CITY OF ALBUQUERQUE

Re: Chase Bank-Indian School Rd
6670 Indian School Road ne
Traffic Circulation Layout
Architect's Stamp 09-03-2020 (J19-D087)

Based upon the information provided in your submittal received 09-09-2020, the above referenced plan cannot be approved for Building Permit until the following comments are addressed:

PLOT DATE
09/01/20
DRAWING SCALE
1" = 20'
PROJECT NUMBER
CDC20013
SHEET NUMBER
C1.01

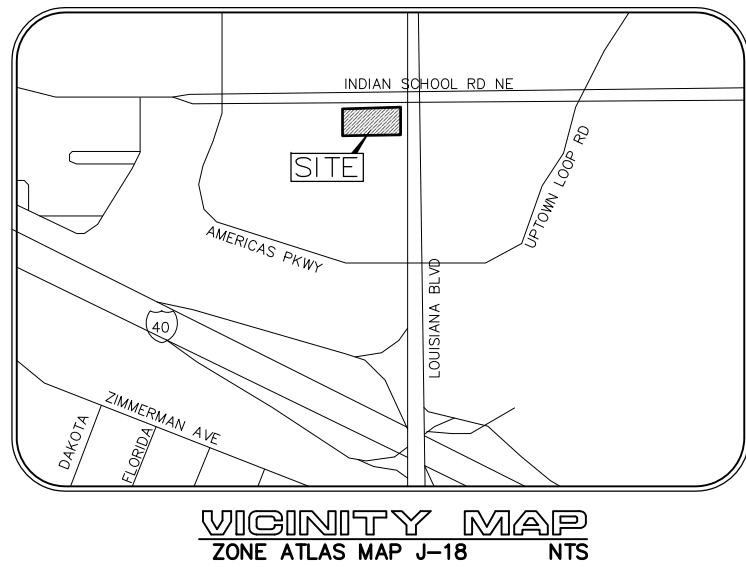
1. The listed number of parking spaces required by the zoning code as well as the proposed number of parking spaces including bicycle and motorcycle parking need to be discussed with Zoning.
2. Identify the right of way width, medians, curb cuts, and street widths on Indian School Road and Louisiana Blvd.
3. Provide existing sidewalk widths public frontage.
4. The **minimum parking stall dimensions** are:

5. Label the compact parking spaces by placing the words "**COMPACT**" on the pavement of each space(**If applicable**).
6. ALL ADA curb ramps must be updated to current standards and have truncated domes installed located within Indian School Road and Louisiana Blvd public frontage.
7. All bicycle racks shall be designed according to the following guidelines(**All bicycle notes -IF APPLICABLE**):
 - a. The rack shall be a minimum 30 inches tall and 18 inches wide.

- b. The bicycle frame shall be supported horizontally at two or more places. Comb/toaster racks are not allowed.
 - c. The rack shall be designed to support the bicycle in an upright position. See the IDO for additional information.
 - d. The rack allows varying bicycle frame sizes and styles to be attached.
 - e. The user is not required to lift the bicycle onto the bicycle rack.
 - f. Each bicycle parking space is accessible without moving another bicycle.
8. Bicycle racks shall be sturdy and anchored to a concrete pad.
 9. A 1-foot clear zone around the bicycle parking stall shall be provided.
 10. Bicycle parking spaces shall be at least 6 feet long and 2 feet wide.
 11. Show all drive aisle widths and radii. Some dimensions are not shown.
 12. The minimum drive aisle dimensions are shown below

13. List radii for all curves shown; for passenger vehicles. Radius for delivery trucks, fire trucks, etc. is 25 ft. or larger.
14. It is not apparent what type of pavement surface is being proposed. A hard driving surface will be required as part of this proposed project for parking area and drive aisles.

15. All one-way drives shall have "**One Way**" and "Do Not Enter" signage and **pavement markings**(Need to be shown at the end of lane where the STOP pavement marking is located). Please show detail and location of posted signs and striping.

16. The minimum drive through lane width is 12 feet with a **25 foot minimum radius (inside edge) for all turns.** (A 15 foot radius can be used with an increase in lane width to 14 feet). Please dimension all lane widths and radii.

17. Sign face detail will be needed for the proposed '**Chase Parking Only Sign**'
18. Provide notes showing what work is included and on the work order and the private work on site.

20. Add a note stating "All broken or cracked sidewalk must be replaced with sidewalk and curb & gutter." A build note must be provided referring to the appropriate City Standard drawing.
